Department Review Status Report

Project Name: BP-2022-13942

REVISION DATE
STATE OF NEW MEXICO RICHARD P. BENNETT No. 1240 4/28/22 REGISTERED ARCHITECT
RBA ARCHITECTURE PC PLANNING DESIGN 1108 Broadway Blvd NE Albuquerque, NM 87102 www.rbaarch.com
DATE 04-28-2022
SHEET NUMBER AS-1.0

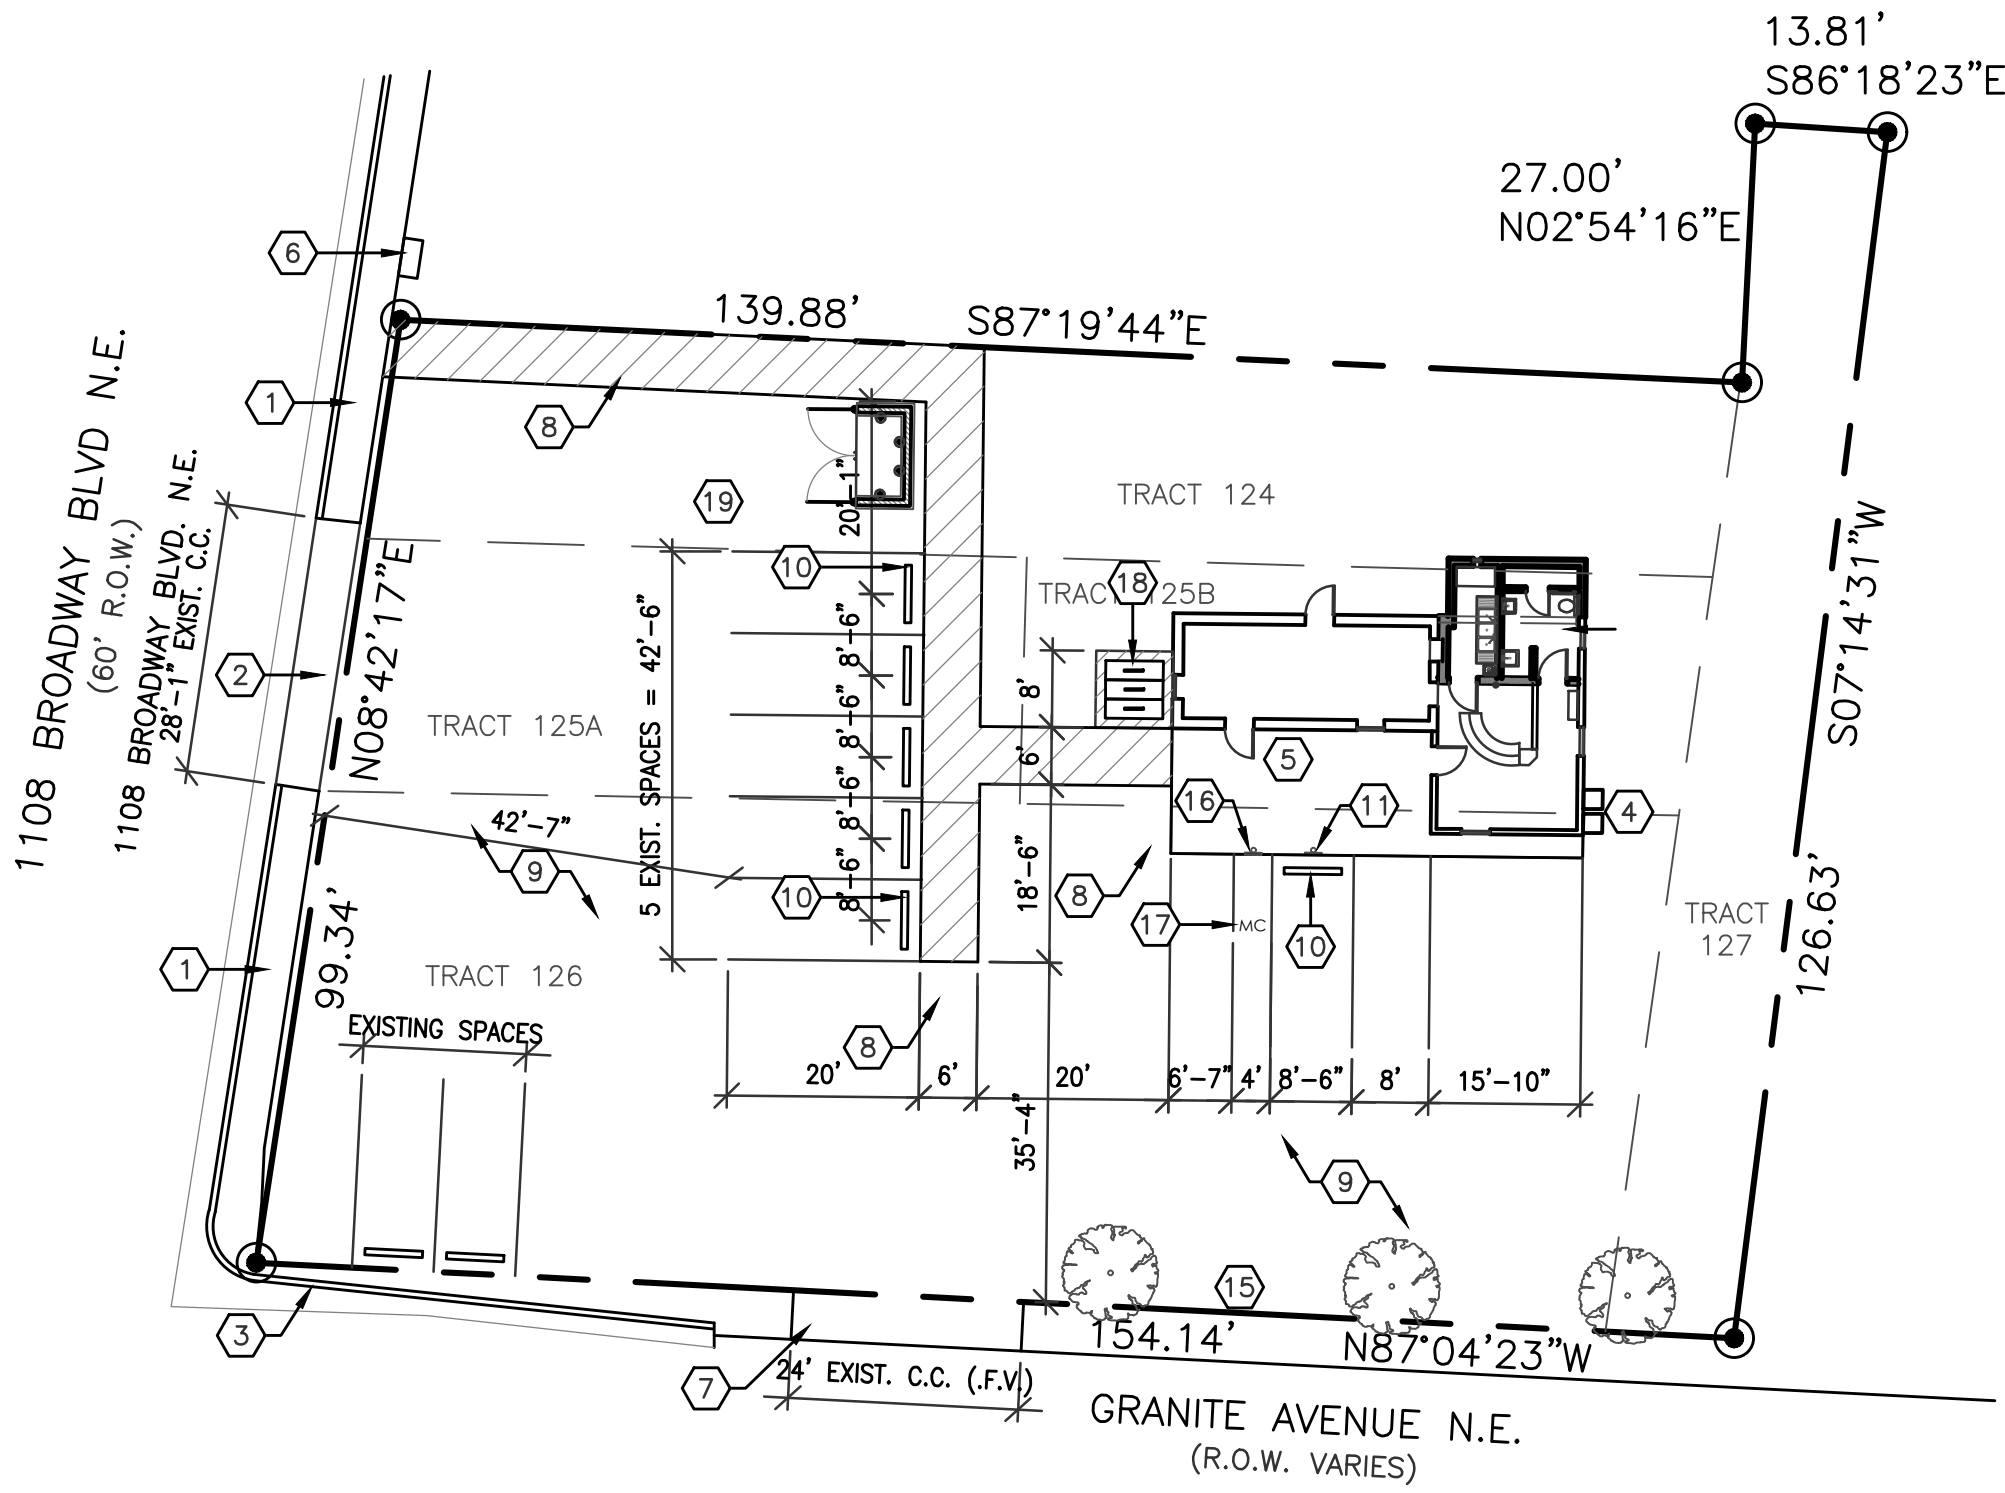
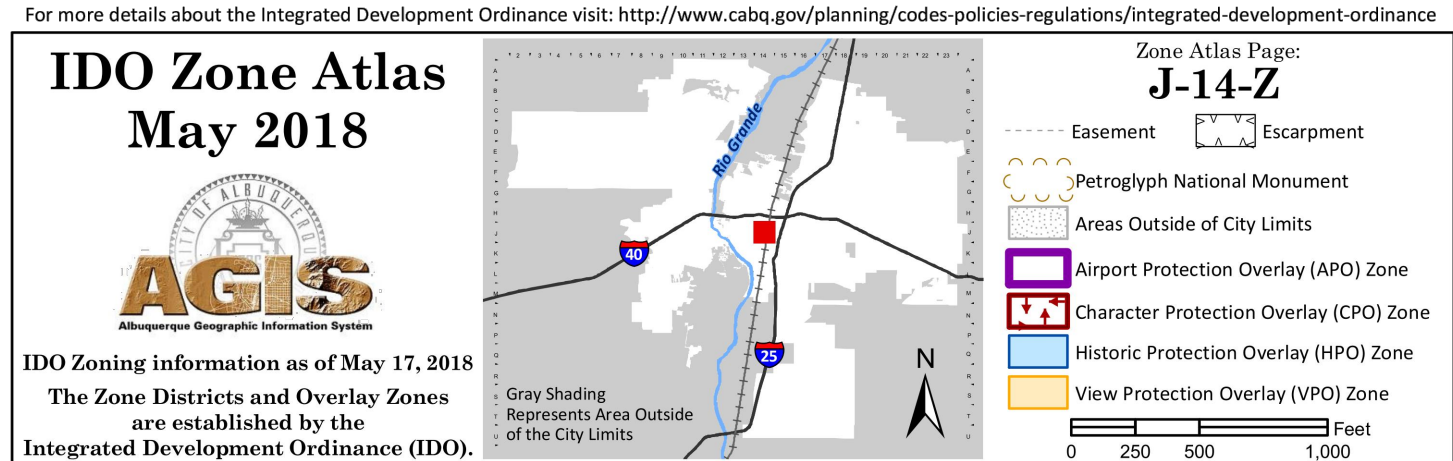
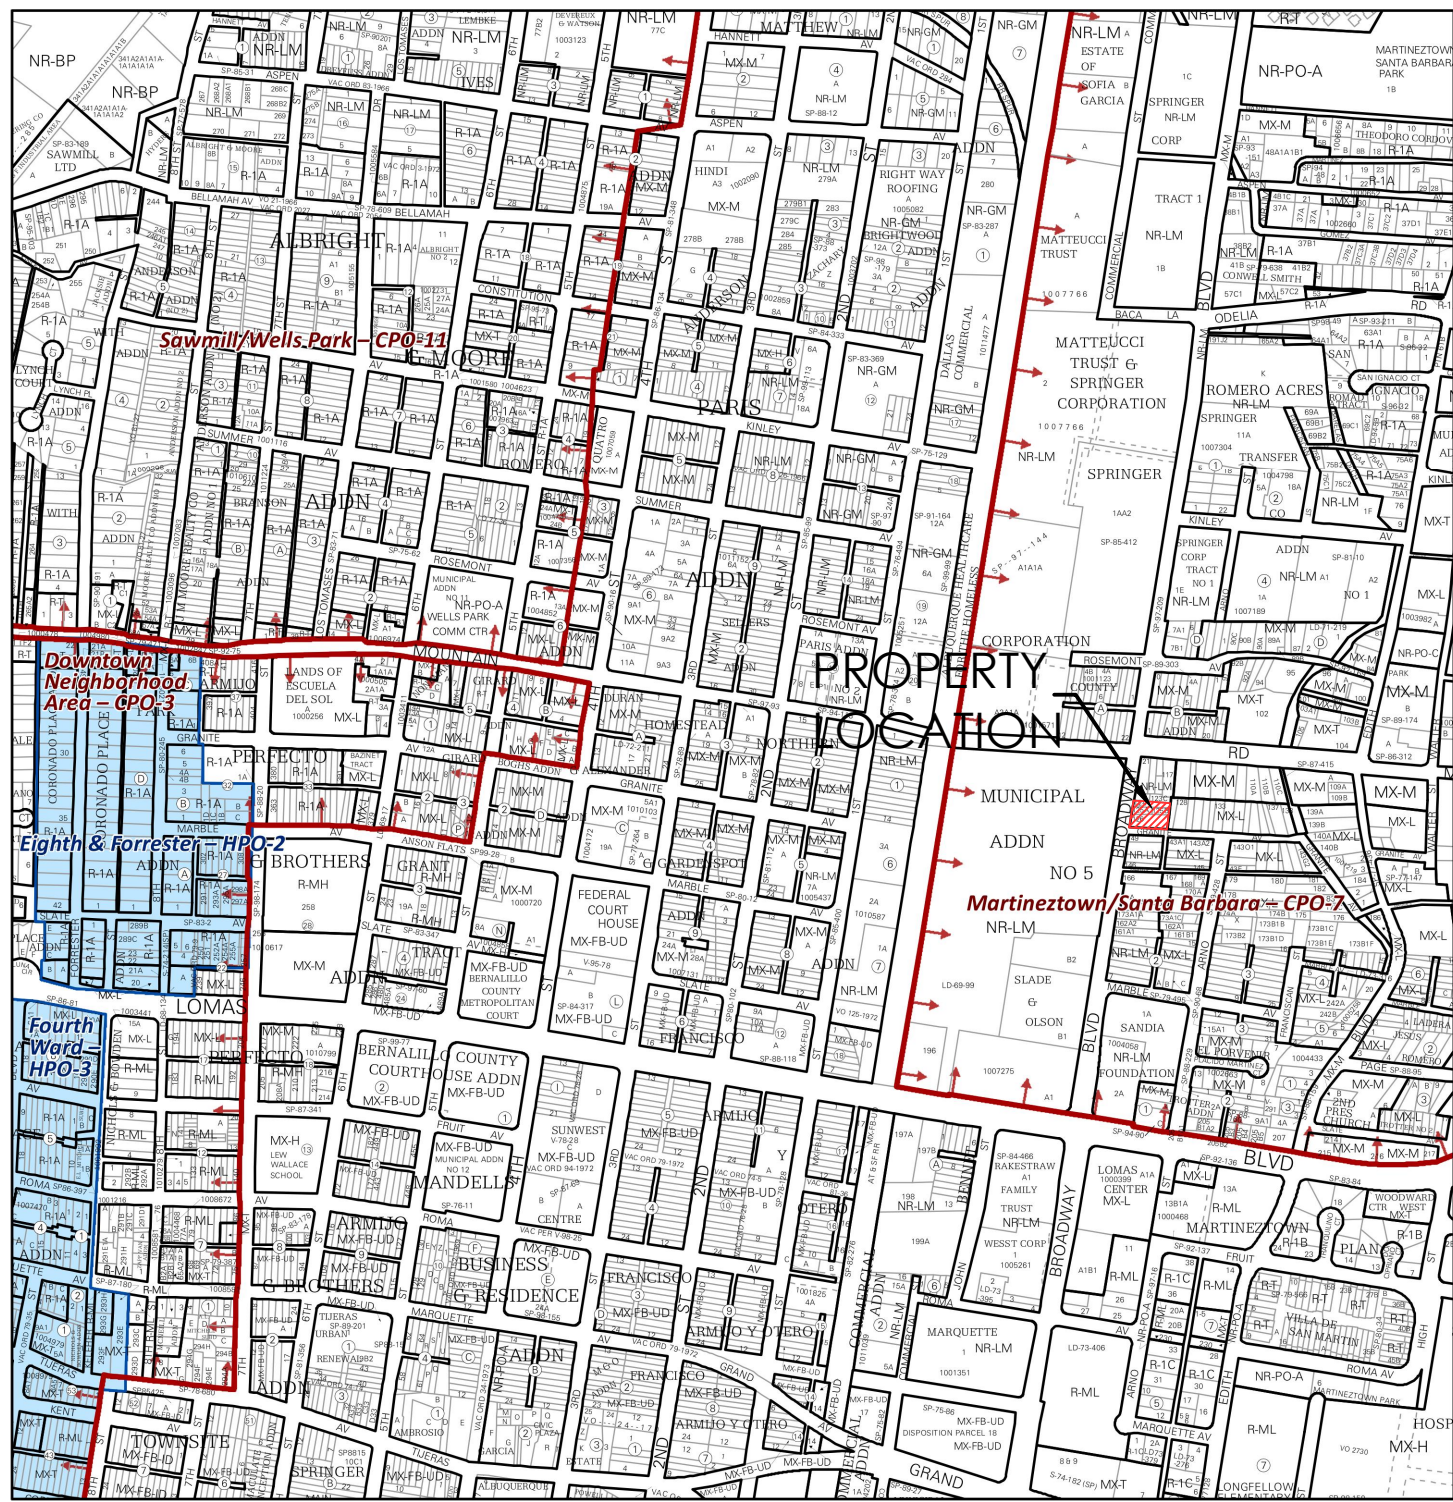
Electrical	Paul Ledoux	pledoux@cabq.gov	Corrections Needed	Please see DWG A-1.0 Home run indicators- Please provide home run indicators with the panel and circuit number. Per UAC 110.3 Energy Code- Please comply with the 2018 IECC Energy Code. (Com Check) Panel Schedule- Please provide a panel schedule for any added, deleted, or existing loads, along with a load analysis. Per UAC 110.3	
	Mechanical	William Ditz	wditz@cabq.gov	Corrections Needed	Final Inspection: Yes *** See drawing A-1.0 for Changemarks. If you have any question please call me, Bill Ditz at (505) 924-3859.	
	Building	Nasima Hadi	nhadi@cabq.gov	Corrections Needed	For Comments: Go to Sheets- A-2, AS-1 Thank you, Nasima 505-924-3961
